**SECTION 96(2) MODIFICATION APPLICATION
ASSESSMENT REPORT
Commercial Development
4 Murray Rose Avenue, Sydney Olympic Park
(SSD 6076 MOD 1)**

Secretary's
Environmental Assessment Report
Modification of consent under section 96(2) of the
Environmental Planning and Assessment Act, 1979

July 2015

Drawing Title
THE LEDGE
DETAIL PLAN

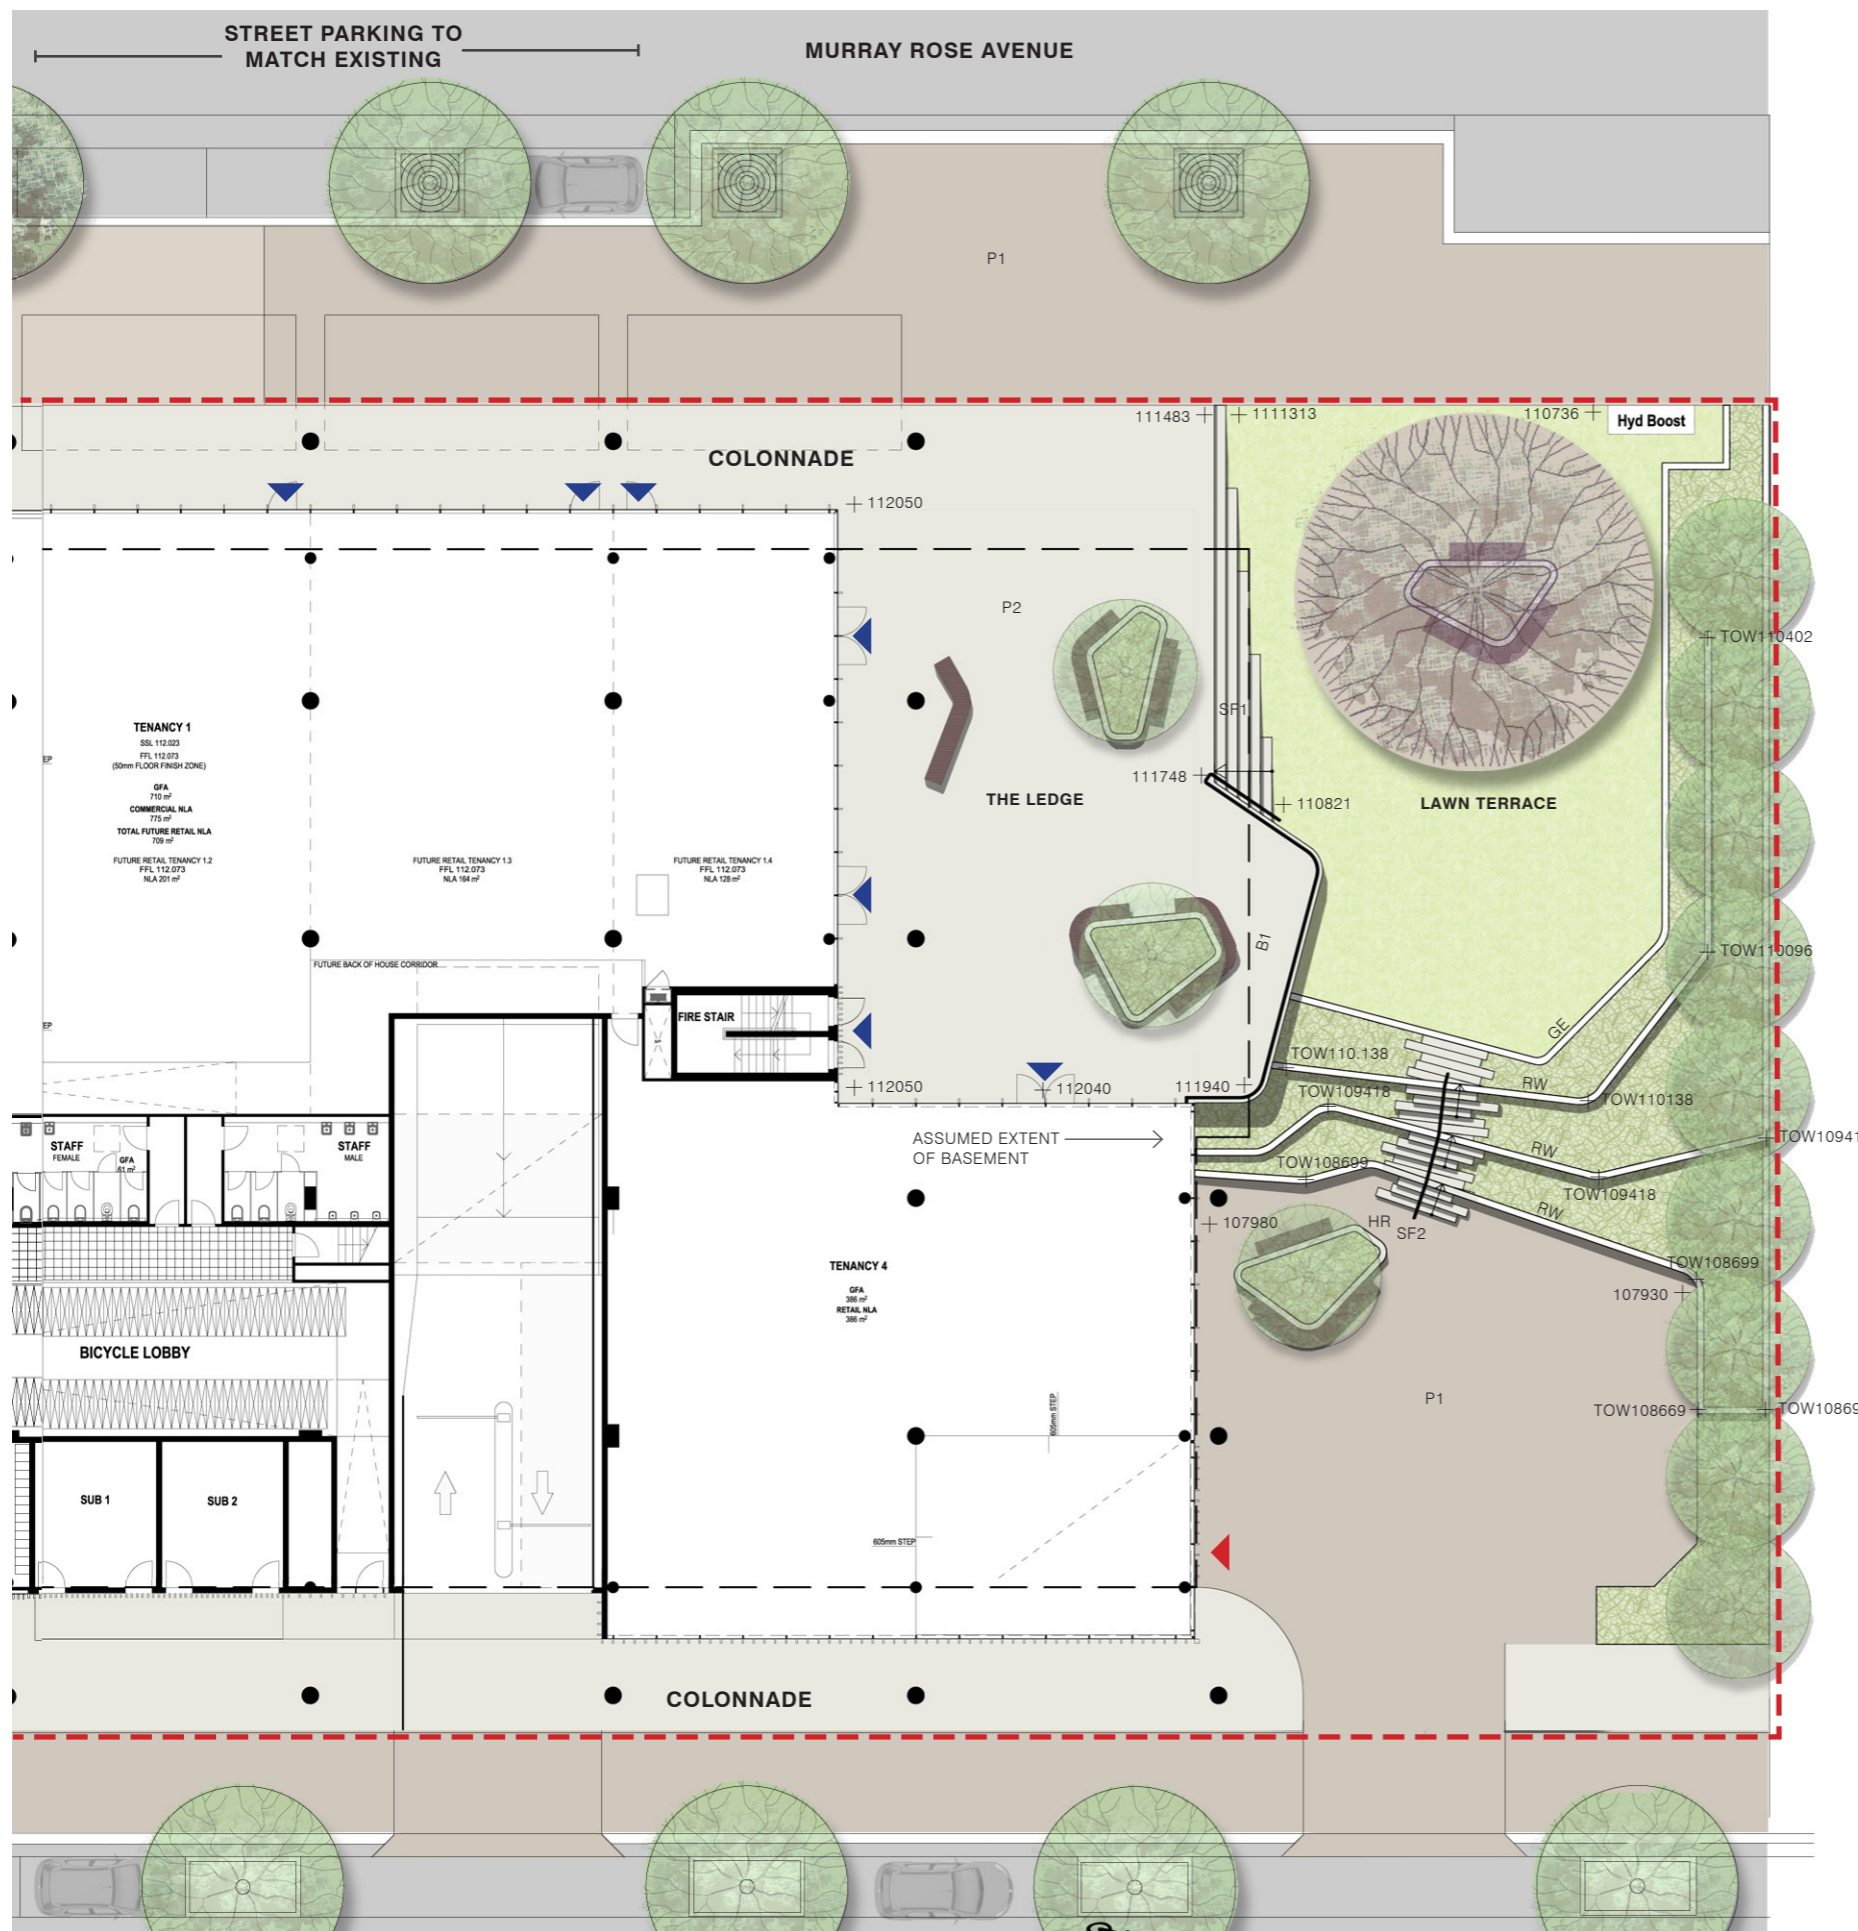
- conflict with access to the loading dock from Dawn Fraser Avenue;
- formalise the through-site pedestrian link (recommended minimum of 1.8 metre pathway) connecting Murray Rose Ave to Dawn Fraser Avenue;
- compliance with the relevant DDA standards for the primary building entrance and the Murray Rose Avenue colonnade;
- a portion of the integral seating to be provided at the base of the colonnade is to include specific elements; and
- the level of amenity proposed for the Paddock Park Temporary Space.

The Applicant liaised directly with SOPA regarding these issues and has submitted revised plans and additional information to address SOPA's concerns. SOPA has confirmed that the changes address its issues subject to a recommended condition that requires associated Landscaping drawings to be amended to reflect the details in the revised Ground Level Plan. The Department supports SOPA's recommended conditions.

| Drawing Title | GENERAL | Context Elevation South and North    | Client | SSO SUBMISSION - S96 | Project No. | EA005 | Rev      | D  |

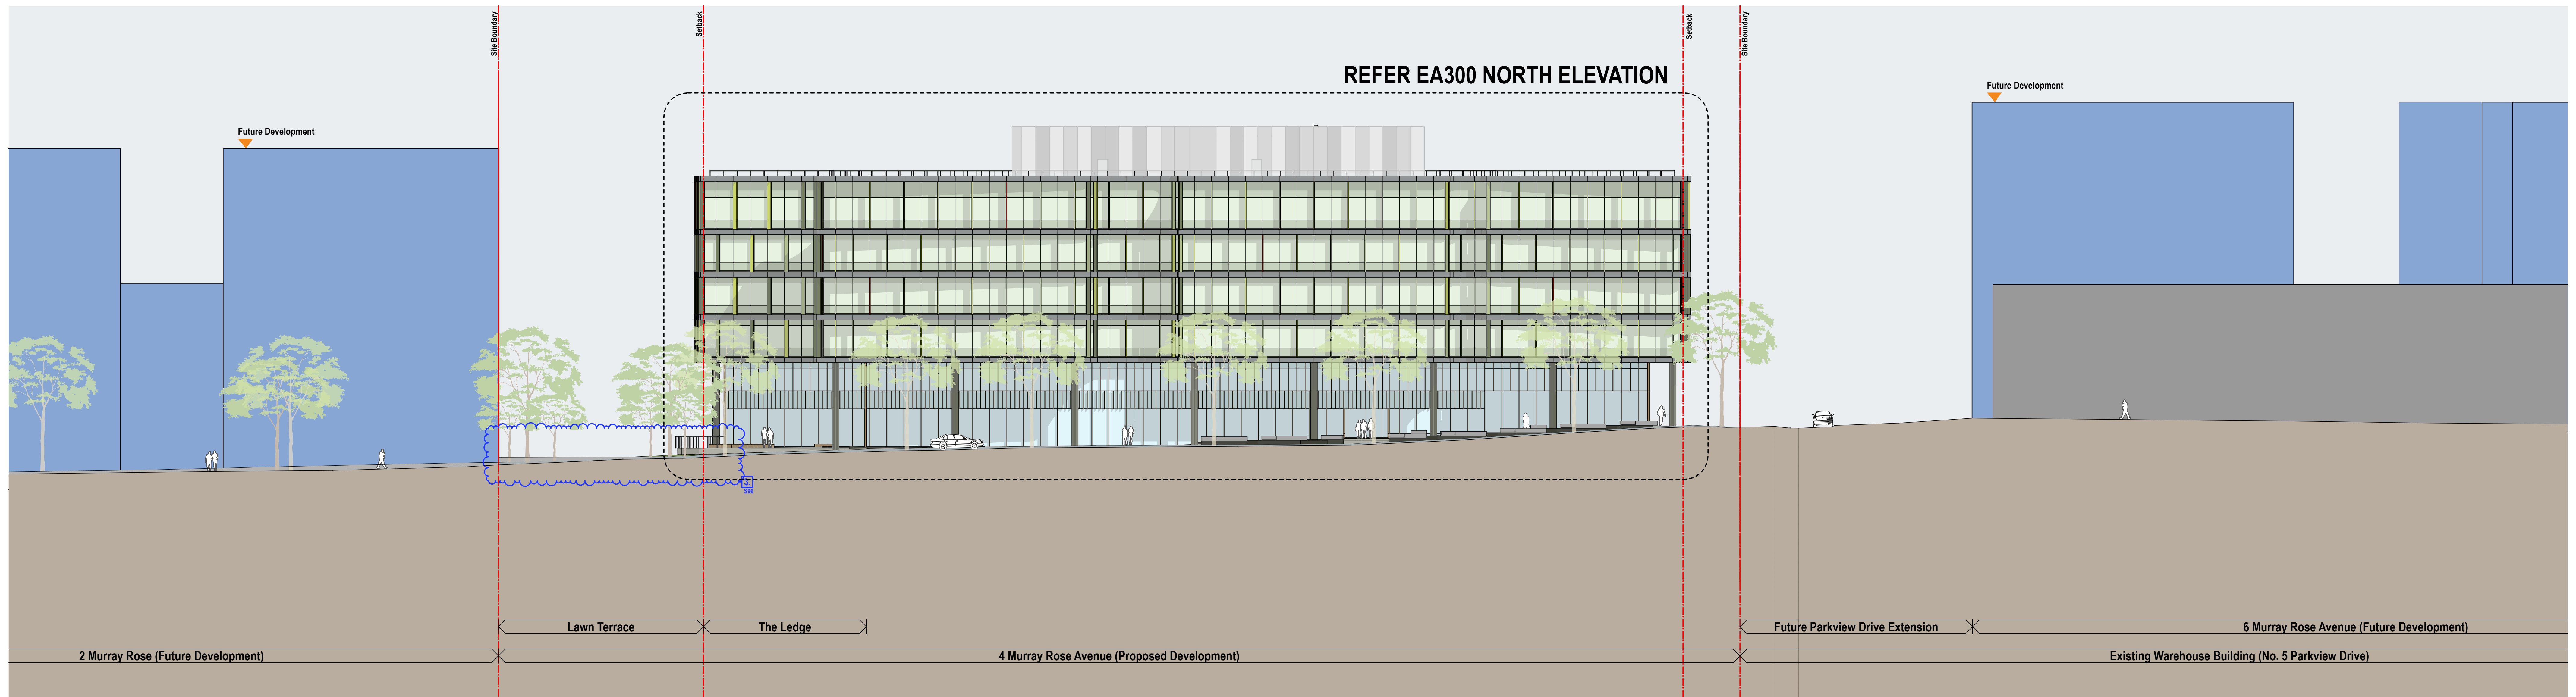
- the relocation of the car park entry/exit from Murray Rose Avenue to Dawn Fraser Avenue;
- the provision of the additional commercial and retail tenancies on the ground floor; and
- a minor refinement of the south-eastern façade (i.e. fronting Dawn Fraser Avenue) and extension of part of the northern façade to the east by 200mm at Levels 2 to Level 5 that is to accommodate the changes proposed as part of this application (**Figure 5**).

The Department considers that the proposed changes are minor in nature and would not substantially alter the approved design which continues to represent a high quality commercial building. The modified building design continues to incorporate appropriate solar access, natural light and ventilation, communal outdoor areas and access to/maintenance of view corridors. Further, the replacement of the building services on the Ground Floor with the addition of the two retail/commercial tenancies would result in an improved urban design outcome for Dawn Fraser Avenue.
